# Transport

## **S75W MODIFICATION FOR 86-96 & 100 MOUNT STREET, NORTH SYDNEY**

Thank you for your letter dated 23 September 2011 regarding the above application. The Department of Transport (DoT) has reviewed the proposed modifications report and provides the following comments for consideration and further discussion with the Department of Planning and Infrastructure (DoPI).

26 PARKING SPACES
 5 MOTORCYCLE SPACES
 68 BICYCLE SPACES

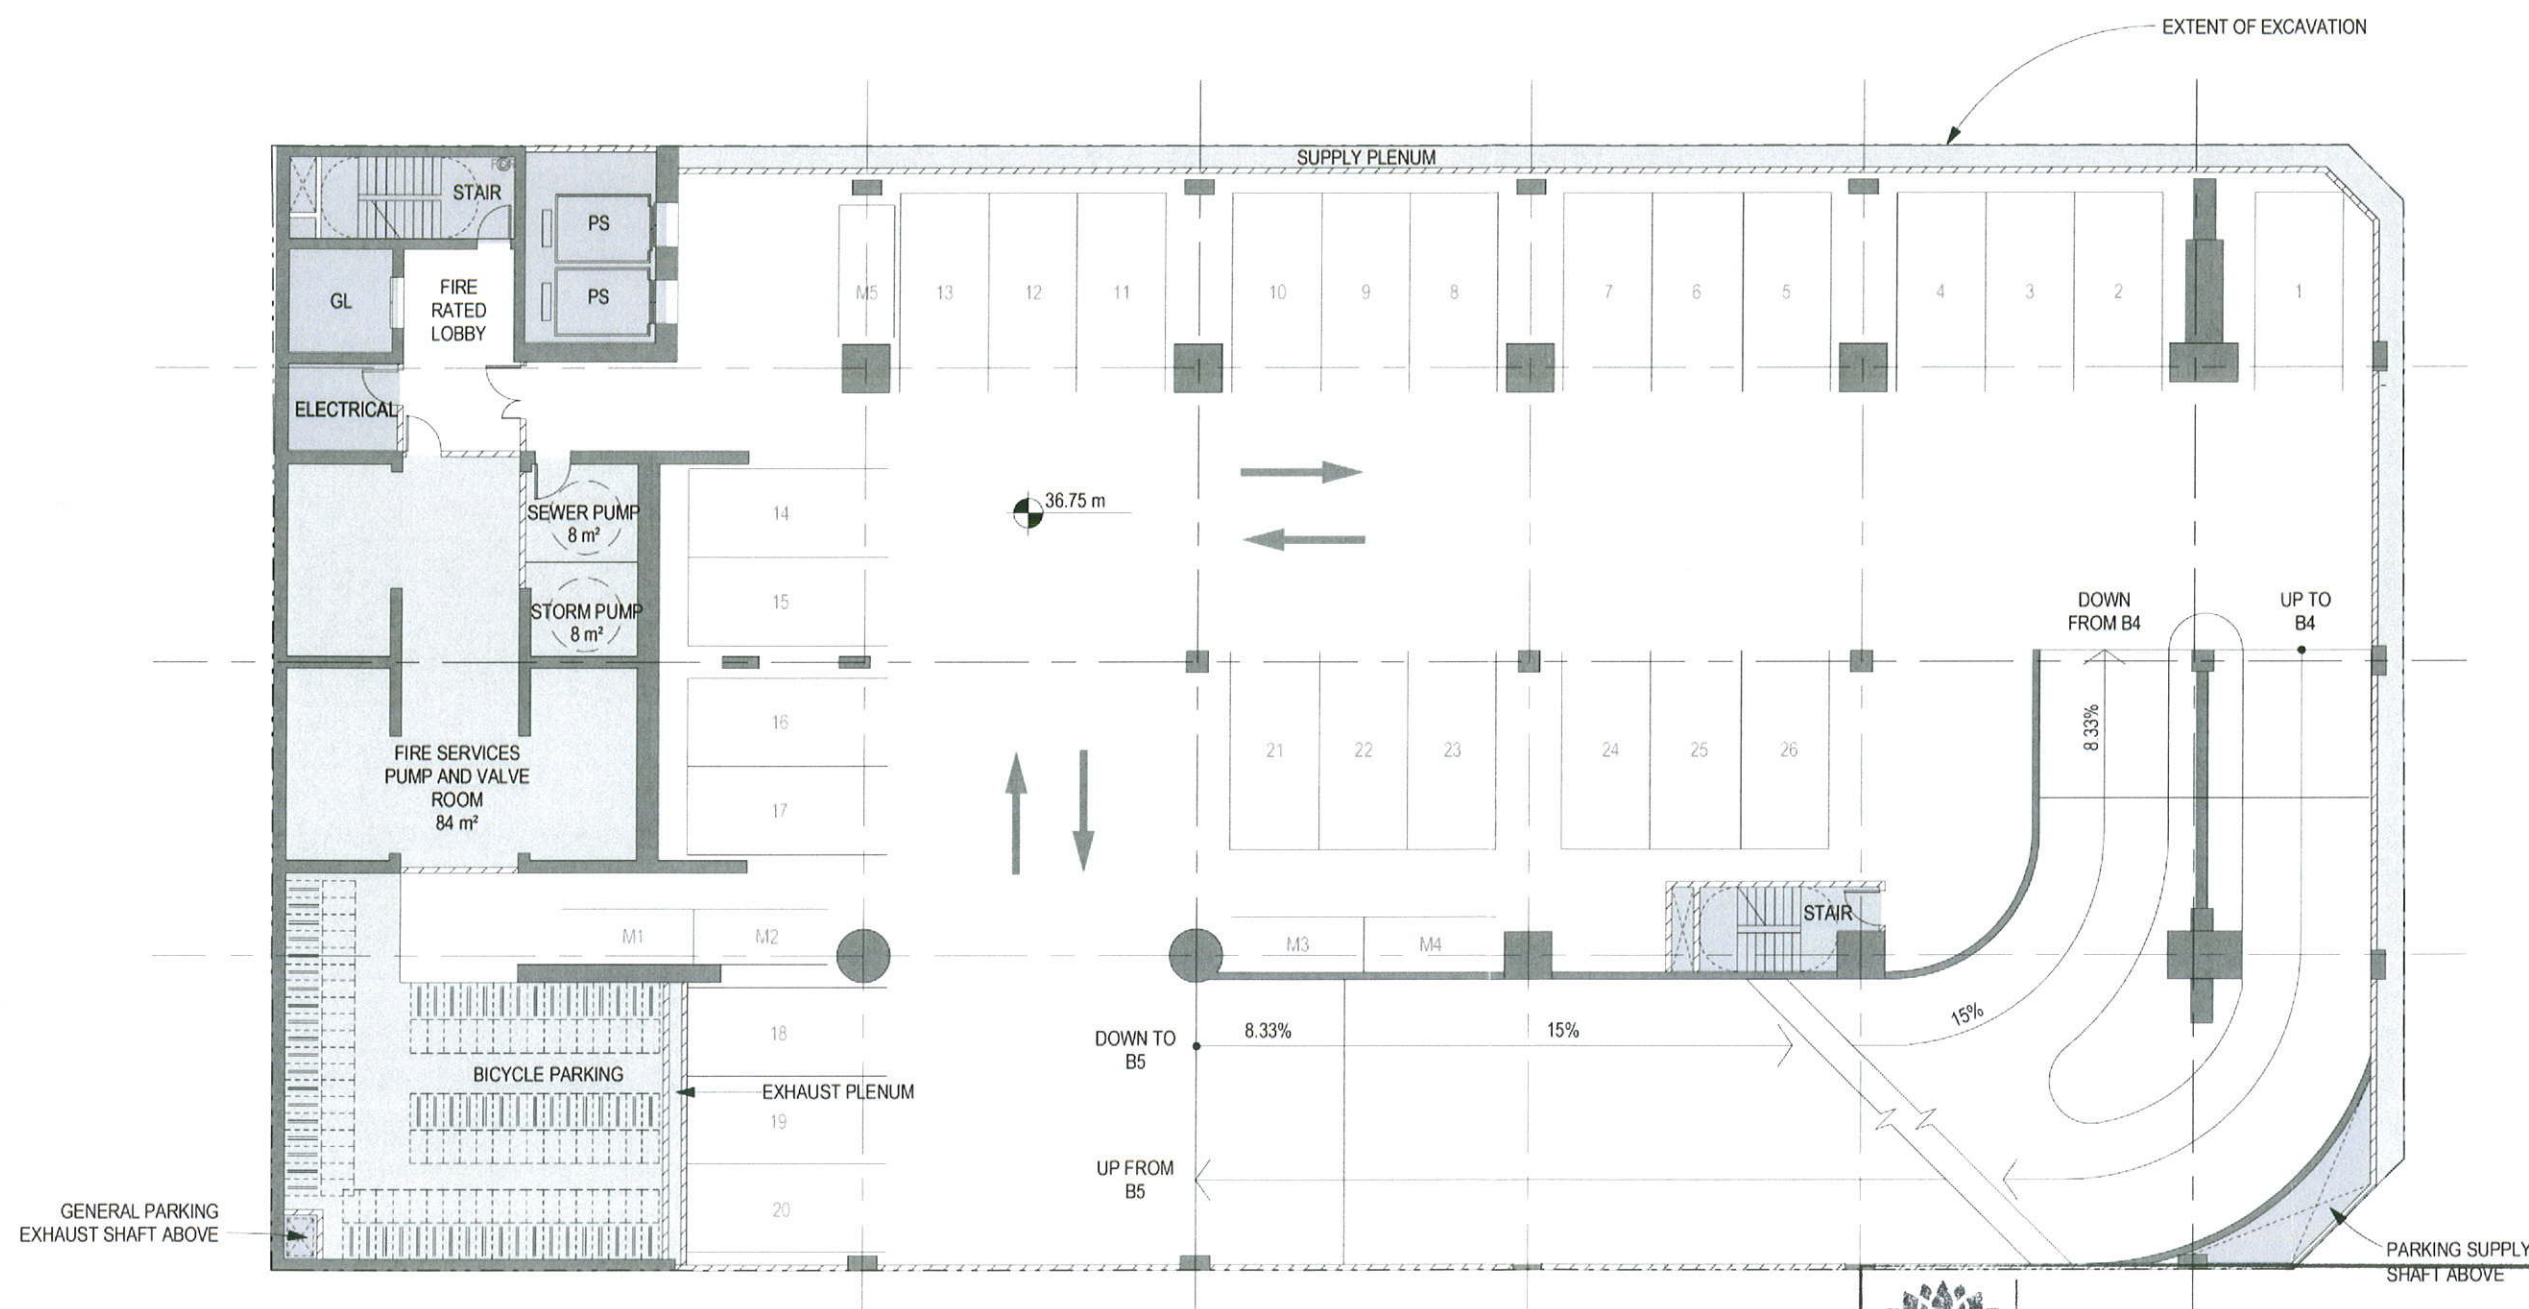
- DoT supports the provision of 272 bicycle parking spaces within the basement levels of the development for workers to site. DoT also recommends the inclusion of bicycle parking at-grade for workers and visitors to site. These facilities should be provided near entrances, in a weather protected location and subject to casual surveillance;
